AT 10 ELIZABETH ST

Proposed Project Description:
add a 10 x 14 sun room, 6' x 7' Deck

Staff Review Checklist

2 ROOF FRAMING PLAN
1/4" = 1'-0"

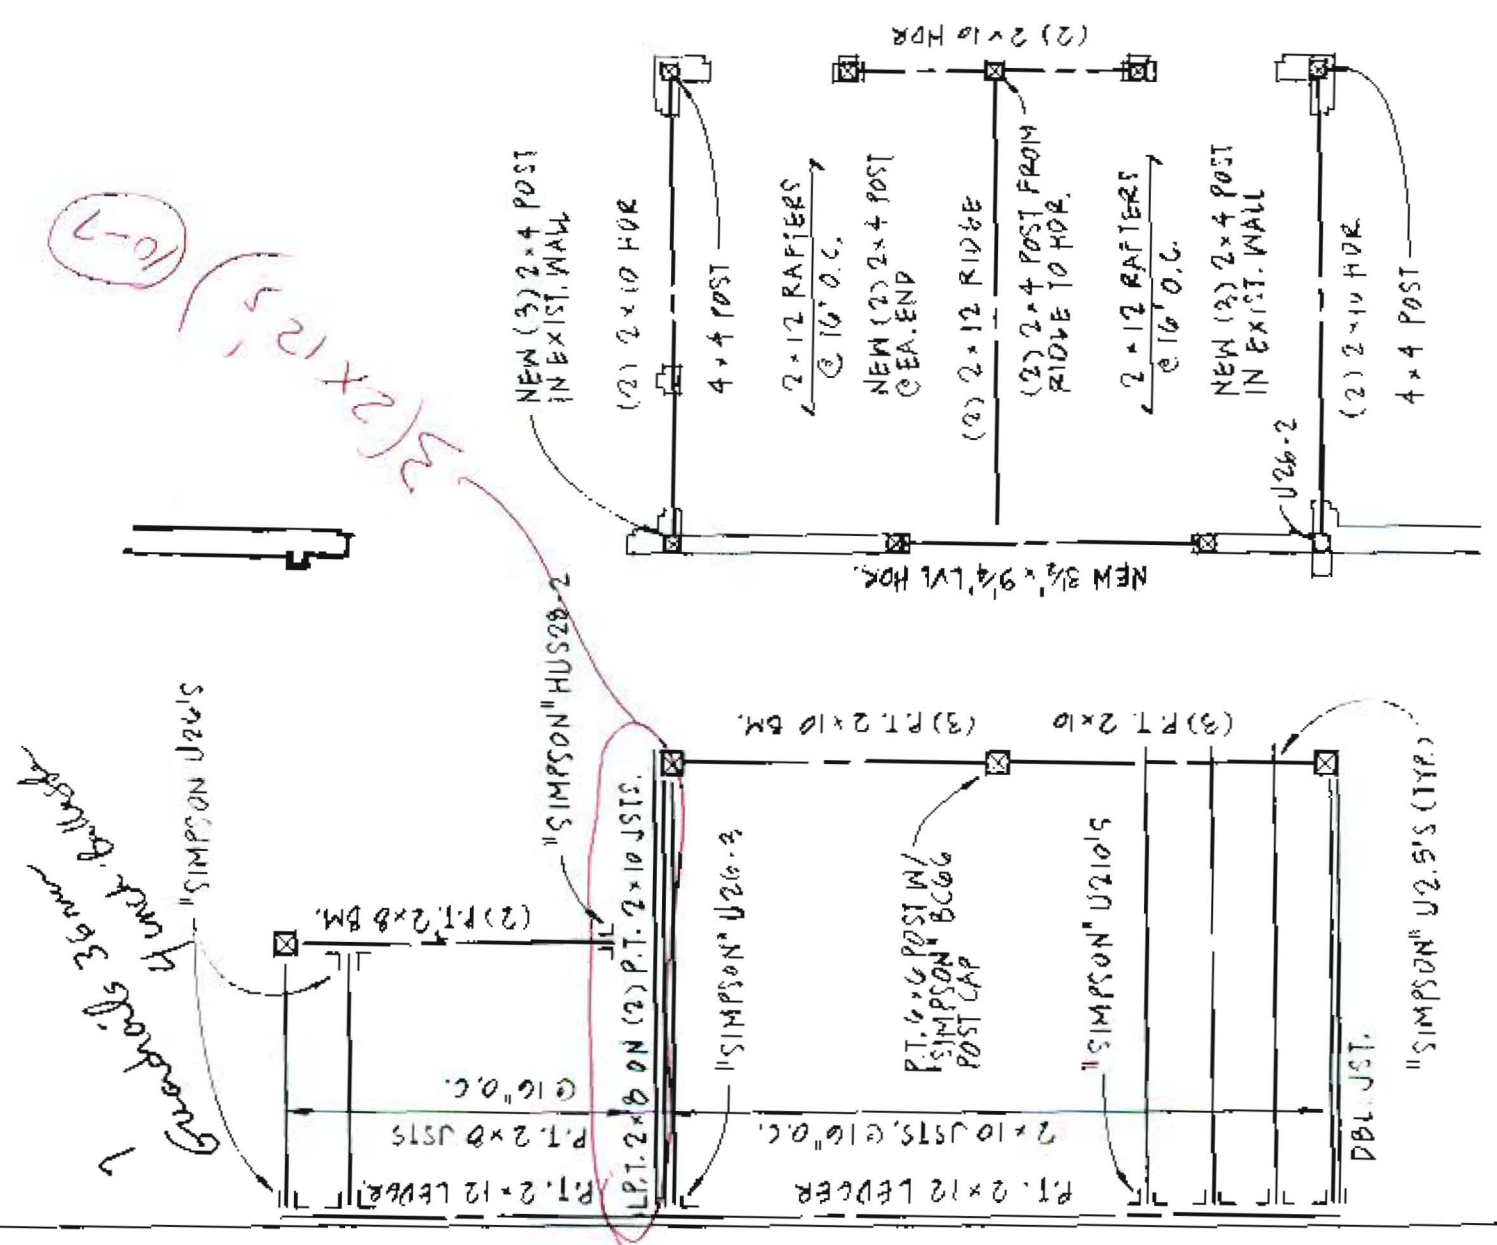
Pitch, Span, Spacing & Dimension (Table R802.5.1(1) - R 802.5.1(8)) Roof Rafter; Framing & Connections (Section R802.3 & R802.3.1)	2x12 Rafters 16" OC 2 (2x12) Ridge	
Sheathing; Floor, Wall and roof (Table R503.2.1.1(1))		
Fastener Schedule (Table R602.3(1) & (2))		
Private Garage (Section R309)		
Living Space? (Above or beside)	NA	
Fire Separation (Section R309.2)		
Opening Protection (Section R309.1)	NA	
Emergency Escape and Rescue Openings (Section R310)	NA	
Roof Covering (Chapter 9)		
Safety Glazing (Section R308)	NA	
Attic Access (Section R807)	NA	
Chimney Clearances/Fire Blocking (Chap. 10)	NA	
Header Schedule (Section 502.5(1) & (2))	2 (2x10)	OK
Energy Efficiency (N1101.2.1) R-Factors of Walls, Floors, Ceilings, Building Envelope, U-Factor Fenestration		
Type of Heating System

FLOOR PLAN FOUNDATION PLAN

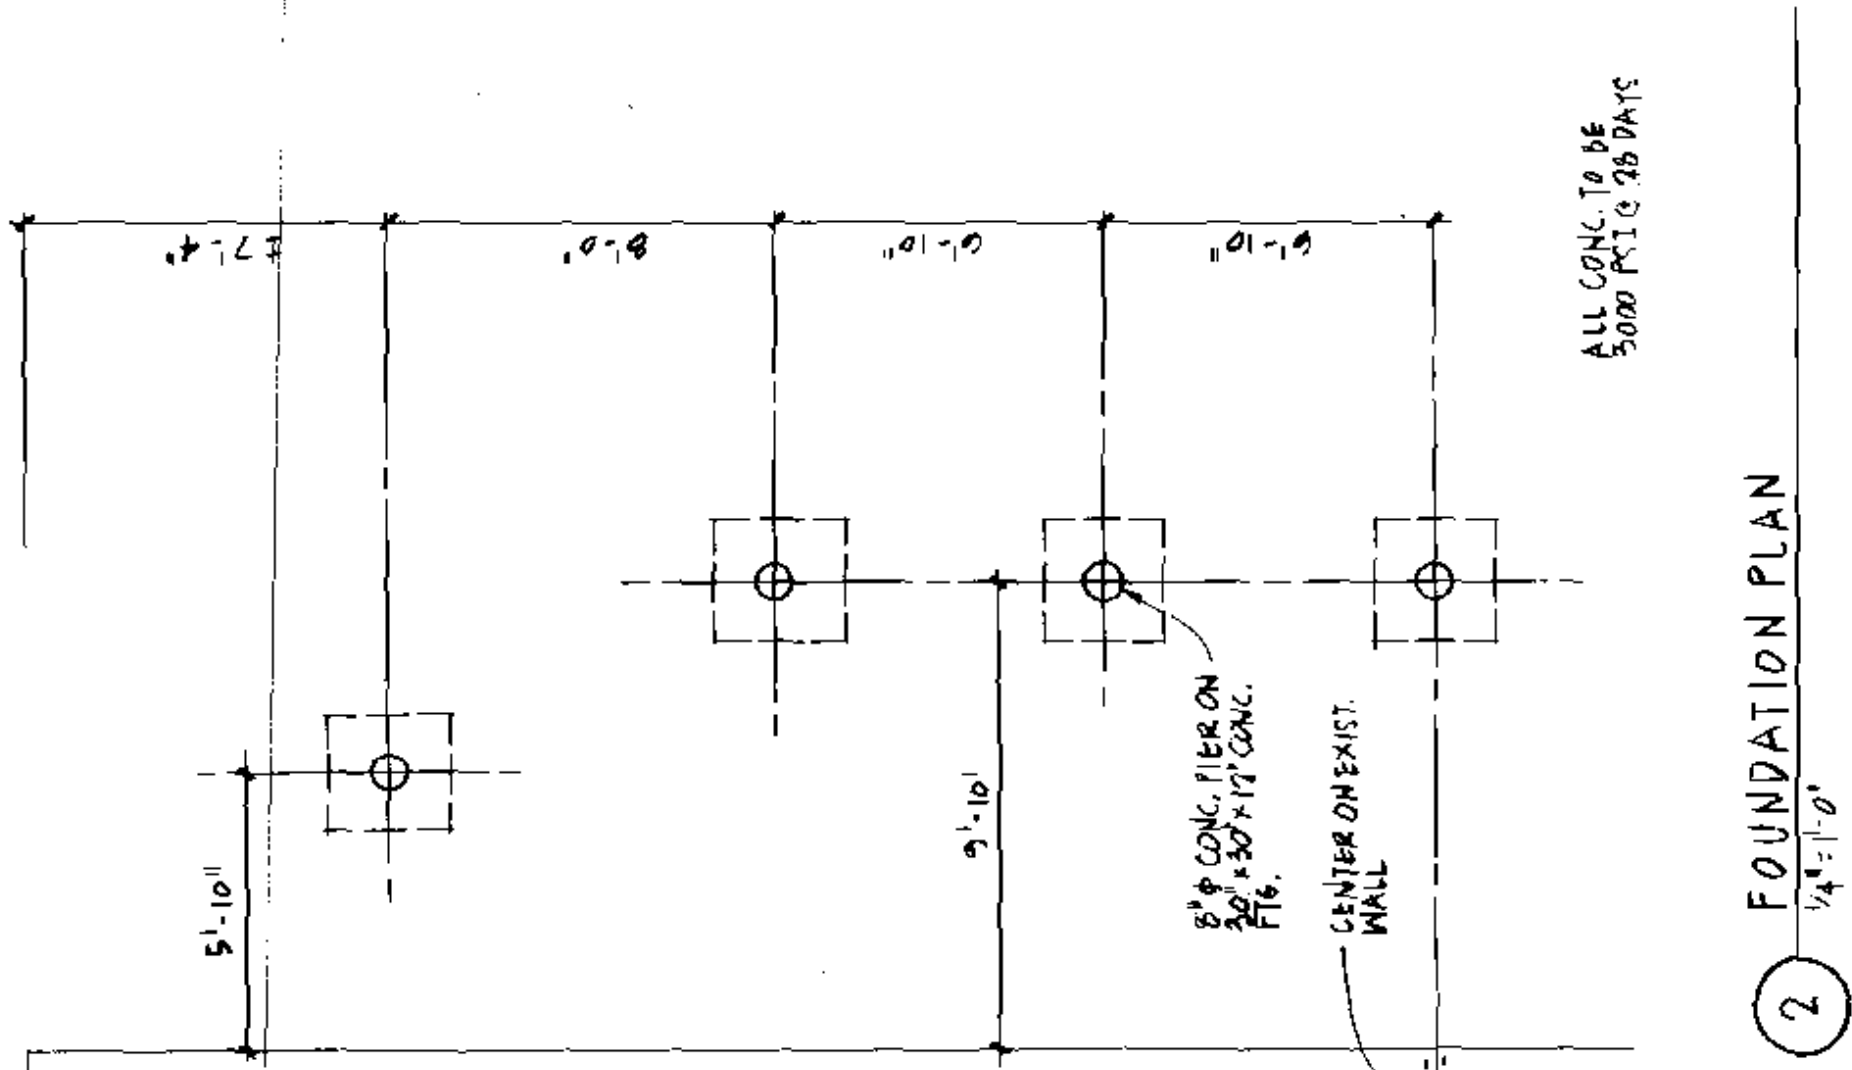
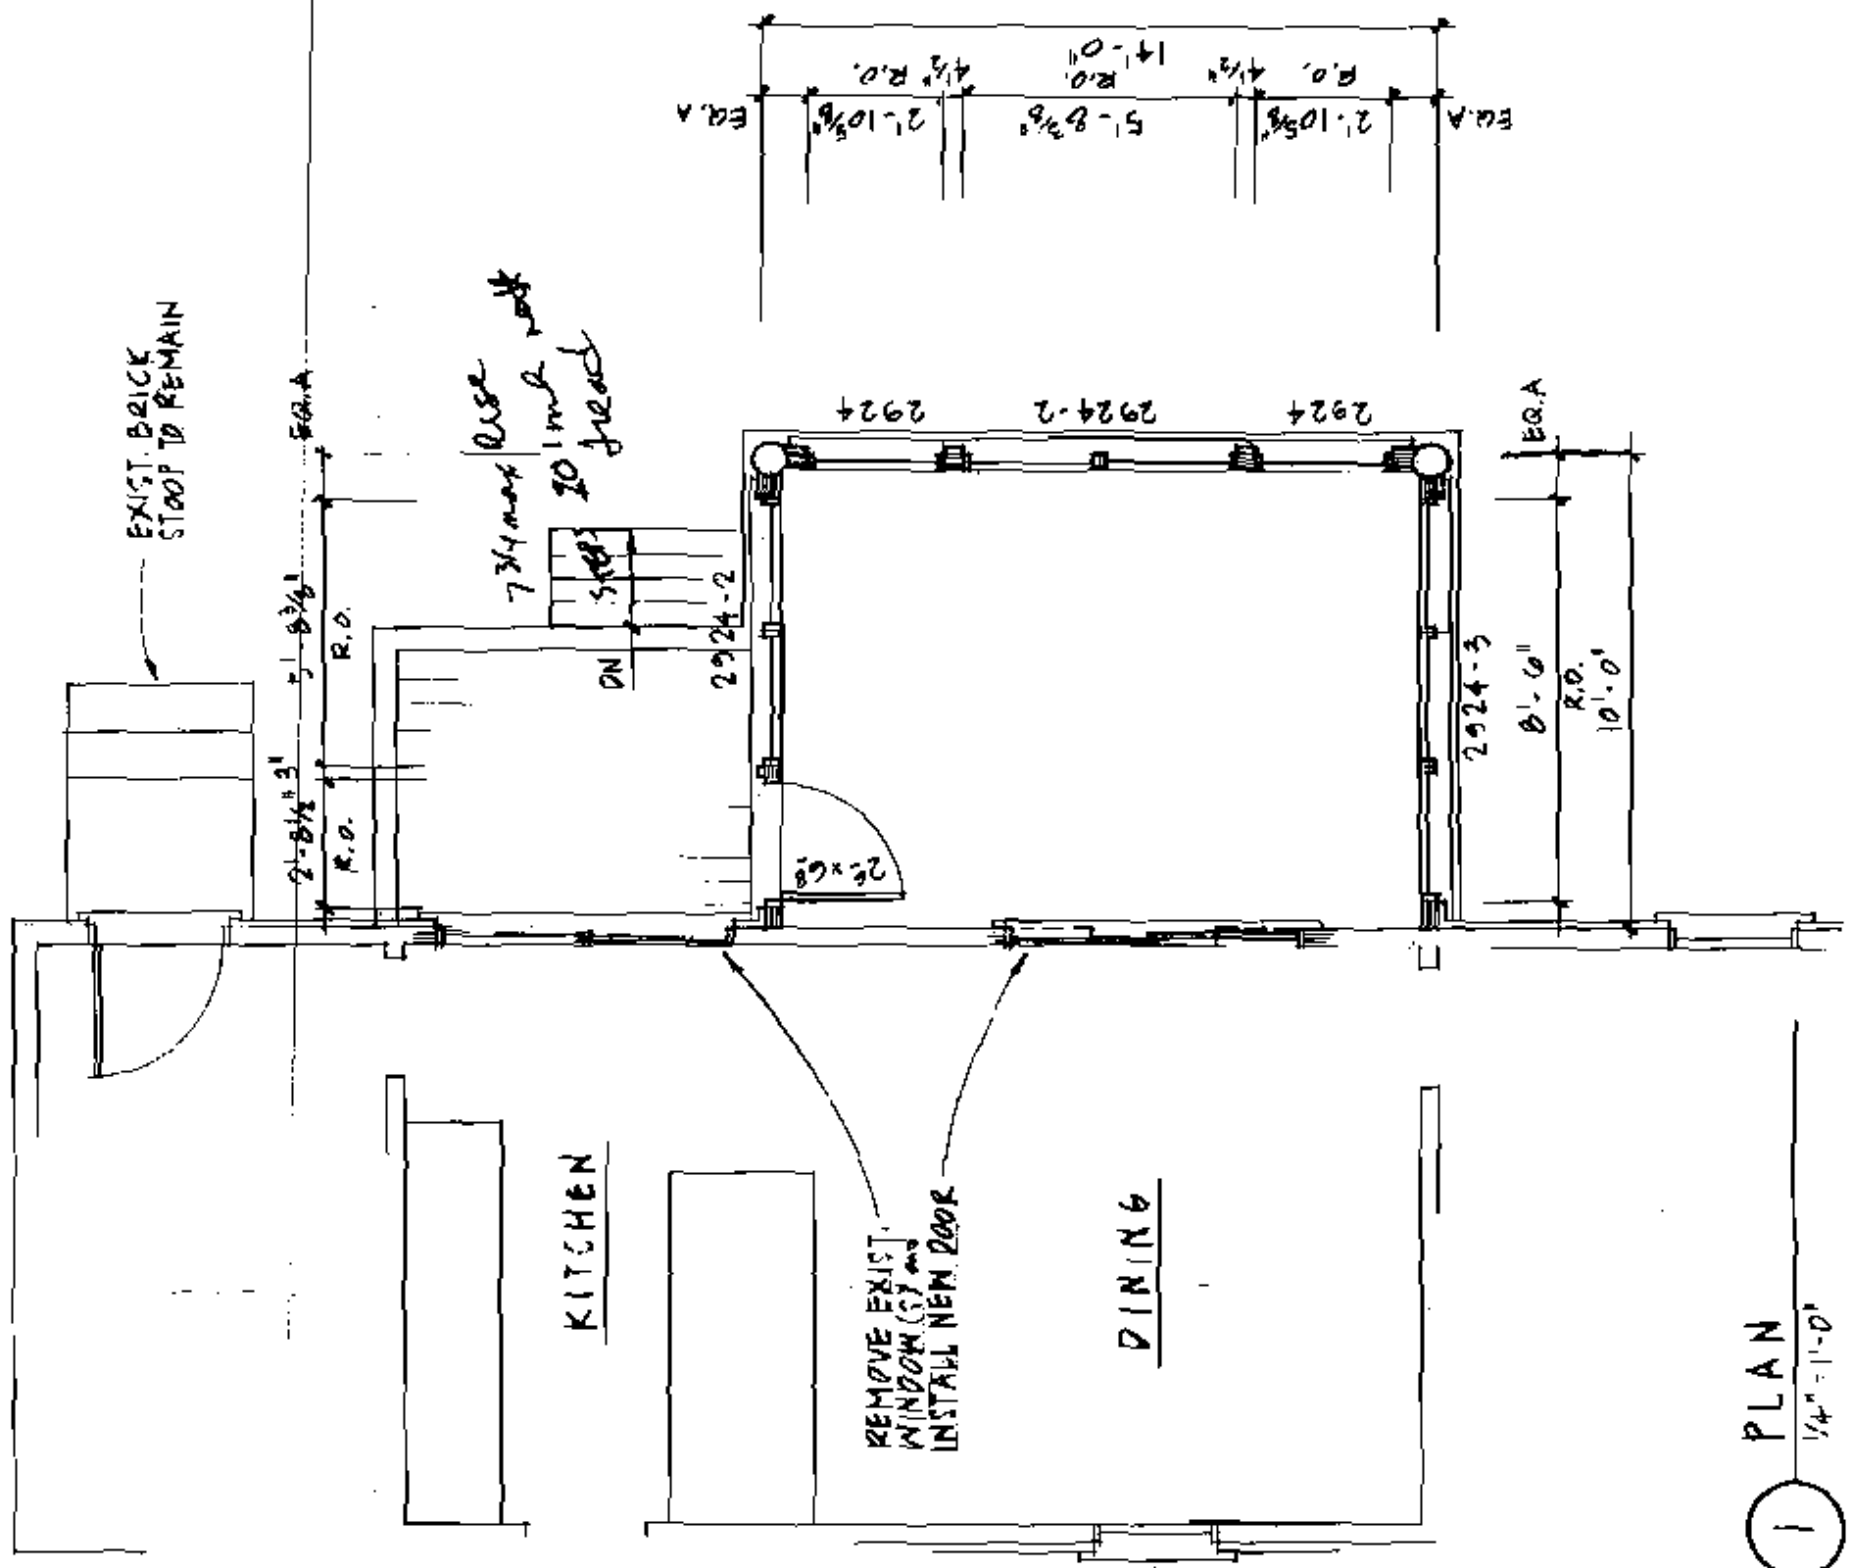
One & Two Family	Plan Review	Checklist
Soil type/Presumptive Load Value (Table R401.4.1)		
Structural	Submitted Plan	Findings/Revisions/Dates
Footing Dimensions/Depth (Table R403.1 & R403.1(1), (Section R403.1 & R403.1.4.1))	4 FT + depth (6 1/2 ft min) 30x30x12 Concrete Ftg	OK
Foundation Drainage, Fabric, Damp Proofing (Section R405 & R406)	NA	-
Ventilation/Access (Section R408.1 & R408.3) Crawls Space ONLY	NA	-
Anchor Bolts/Straps, Spacing (Section R403.1.6)	NA Simpson 426-3 Simpson 42105	OK
Lally Column Type (Section R407) Girder & Header Spans (Table R 502.5(2))	(2) 2x10 HEADERS (2) 2x12's (2) 2x12's OK	OK
Built-Up Wood Center Girder Dimension/Type	3(2x10's)	OK
Sill/Band Joist Type & Dimensions	2x10 16" OC	OK
First Floor Joist Species Dimensions and Spacing (Table R502.3.1(1) & Table R502.3.1(2))	NA	-
Second Floor Joist Species Dimensions and Spacing (Table R502.3.1(1) & Table R502.3.1(2))	NA	-
Attic or Additional Floor Joist Species Dimensions and Spacing (Table R802.4(1) & R802.4(2))	NA	-
